DEVELOPMENT REVIEW BOARD
SUPPLEMENTAL SUBMITTAL

PROJECT NO. PR-2021-005467
Application No. SI-2022-00861

Re: Raising Cane's (4800 Montgomery Blvd NE) PR-2021-005467

Please find the following responses addressing comments received in a letter dated May 4, 2022 from the One Albuquerque Planning:

Sheet Title:  
**SITE KEYNOTE PLAN**  
 Date: 07.07.2022  
 Project Number: 090042000  
 Drawn By: LW/LN  
 Sheet Number:

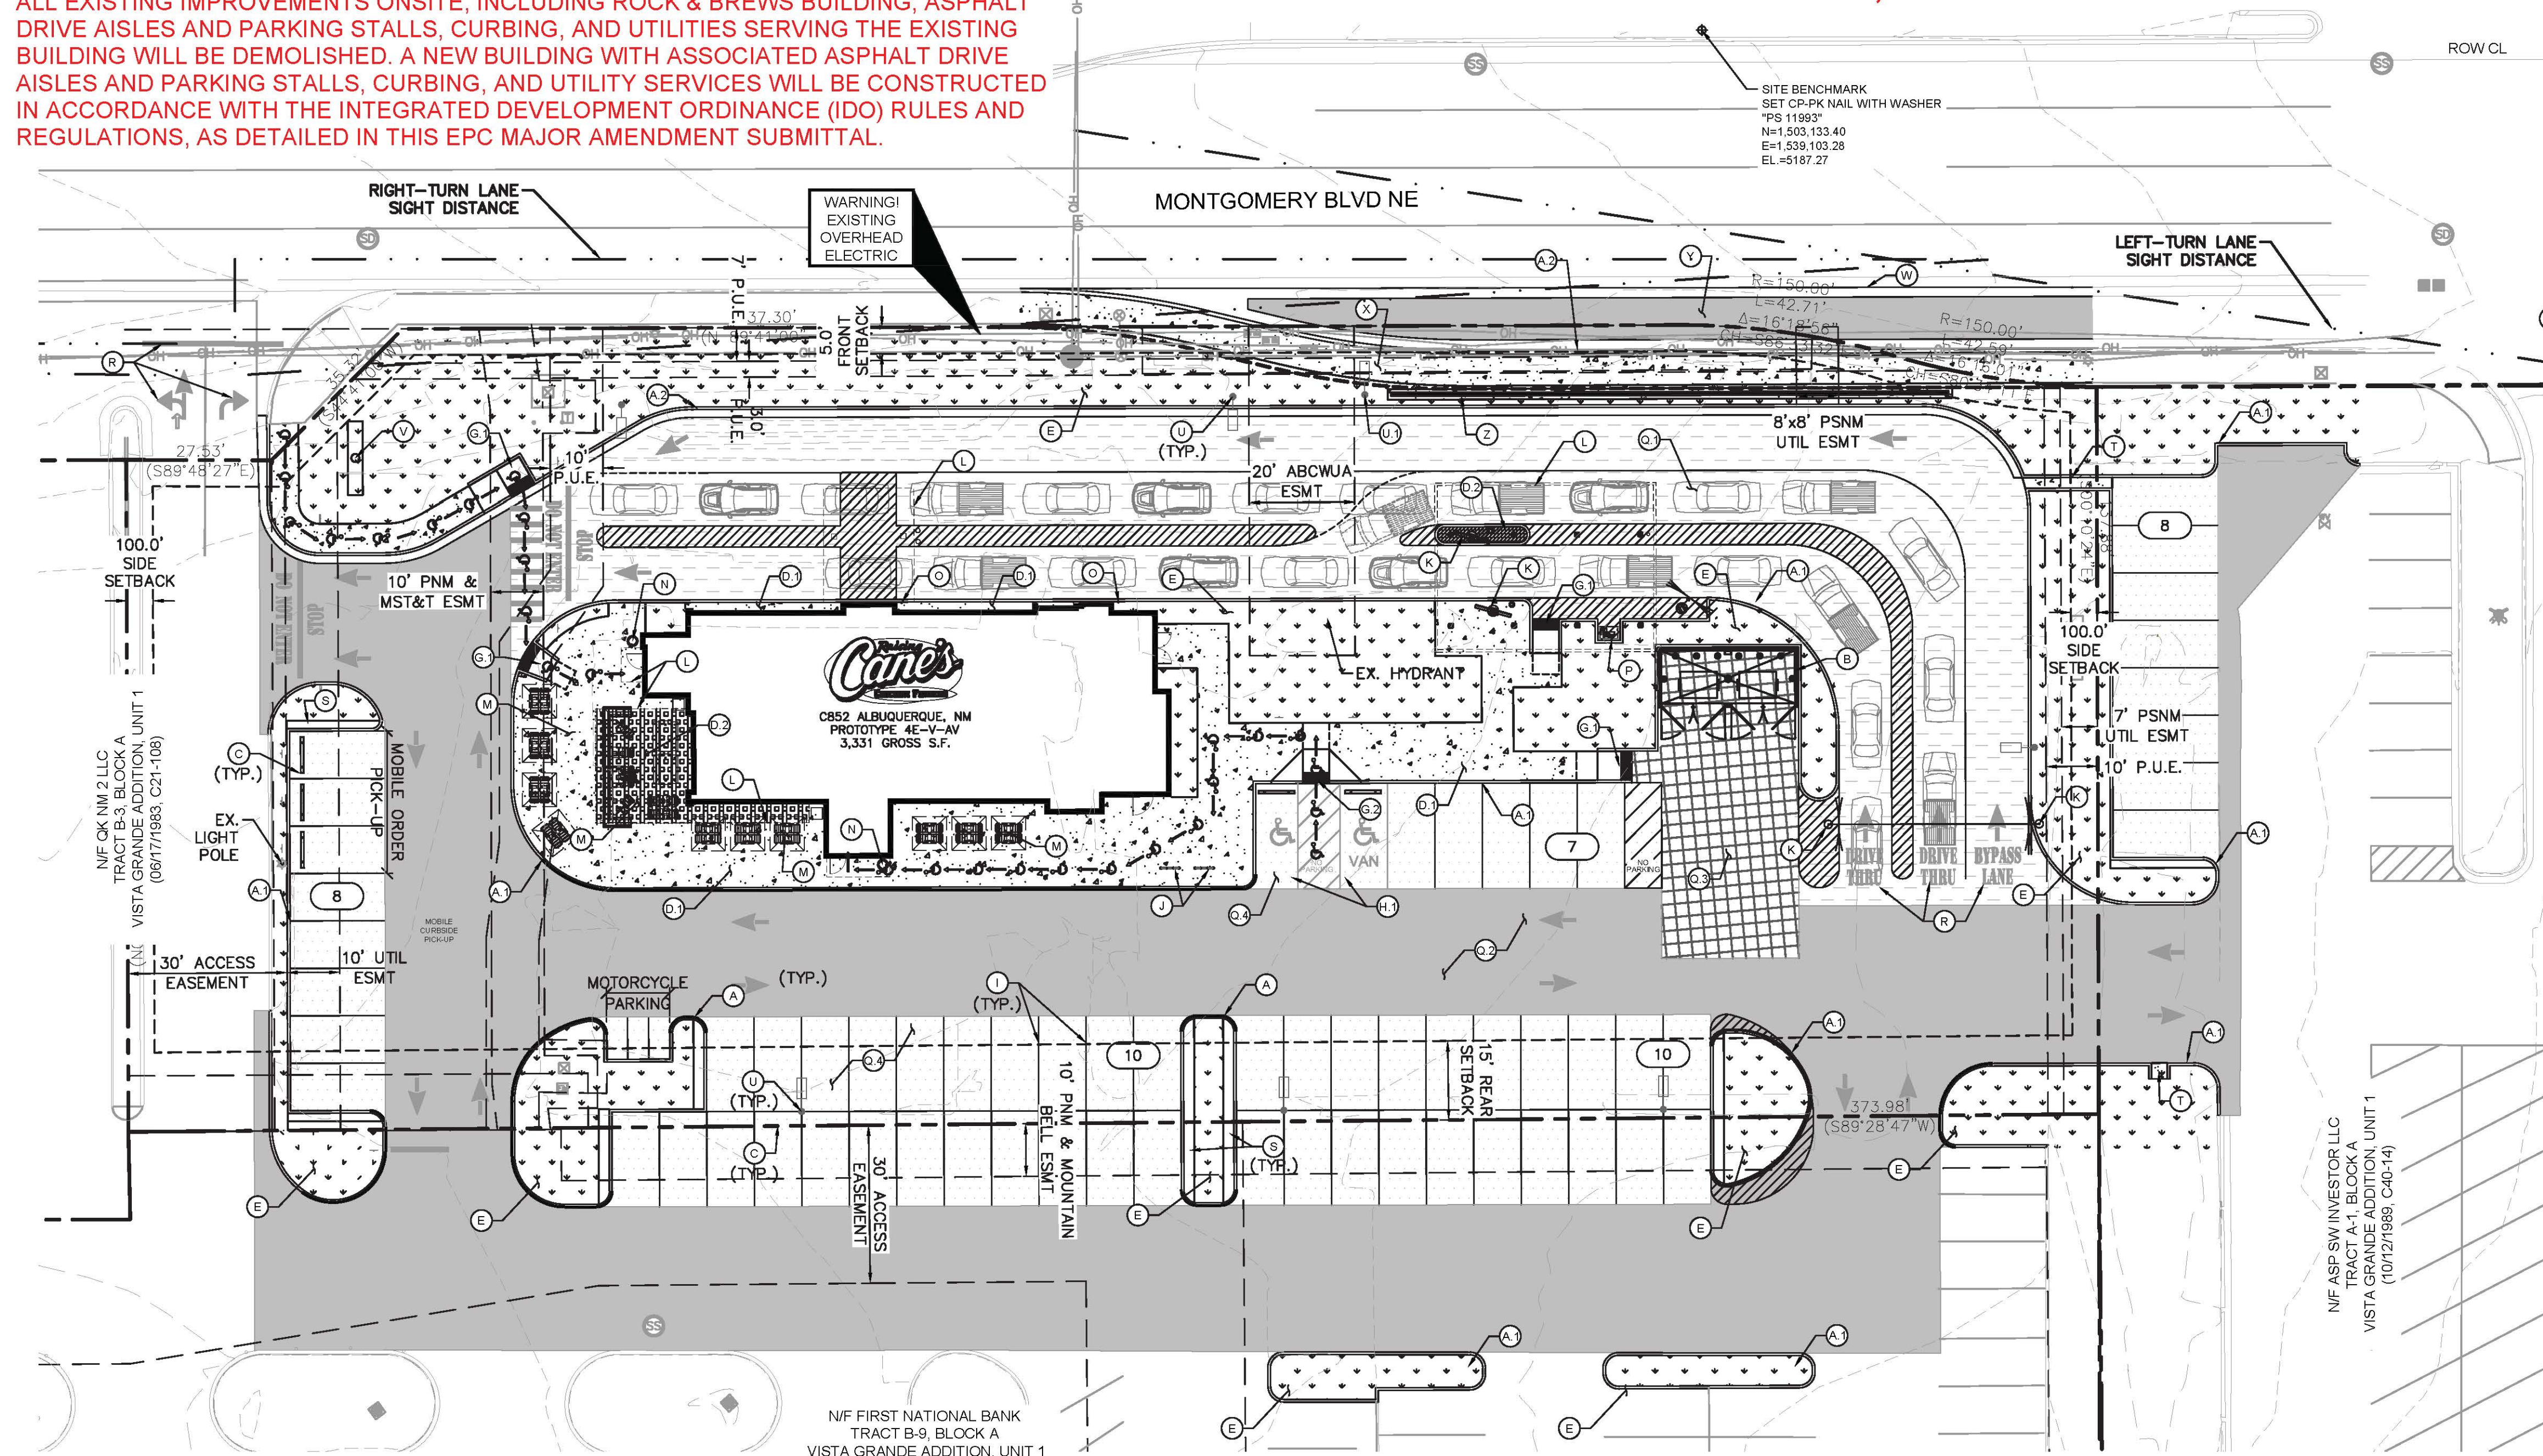
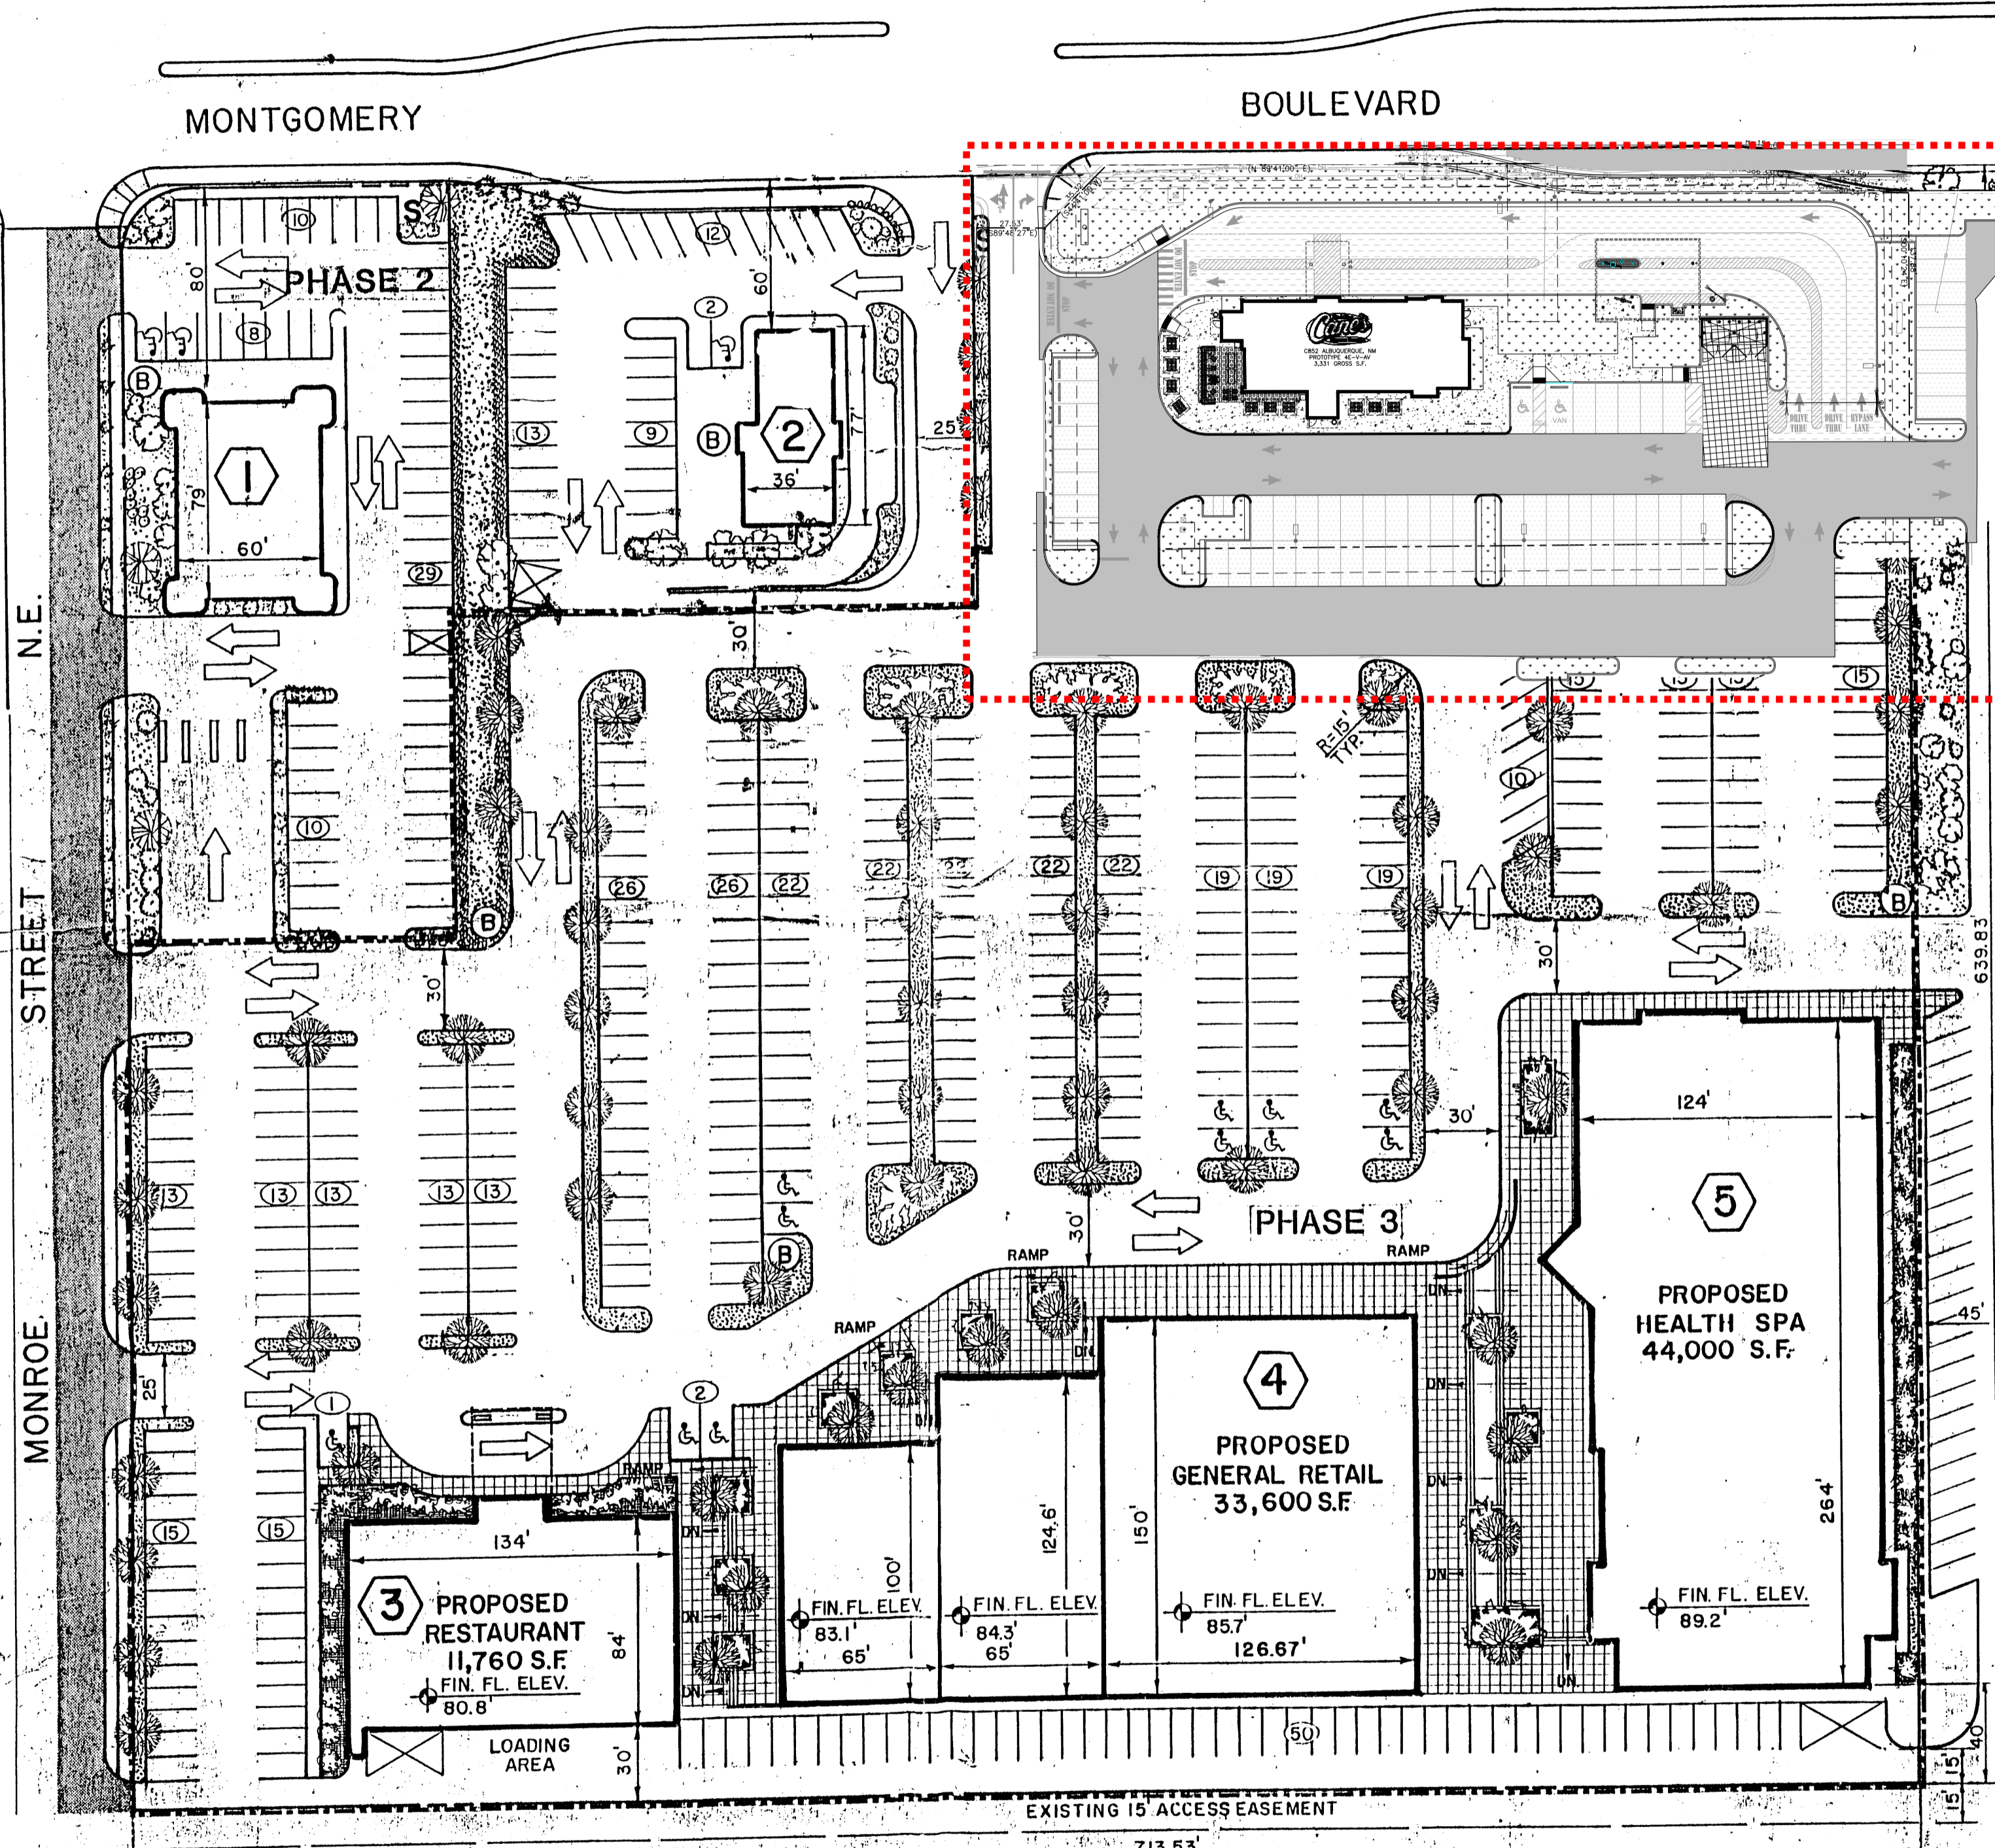
Comment 1: Signature blocks for DRB members and Solid Waste must be added to the Site

Comment 2: The project and application numbers must be added to the Site Plan

Comment 3: On separate sheet, show queue for the drive-thru at 20-foot lengths.

Comment 8: Show clear sight triangles along with the standard note on landscape height restrictions. Use intersection clear sight distance along Montgomery Blvd. Specify on both site plan and landscaping plan

Response 1: Comment addressed, see sheet C5.0 – Site Keynote Plan.

Response 2: Comment addressed in C5.0 Keynote Plan.

Response 3: Comment noted, see sheet C5.0 – Site Keynote Plan.

Response 8: Comment noted, see sheet C5.0 – Site Keynote Plan.
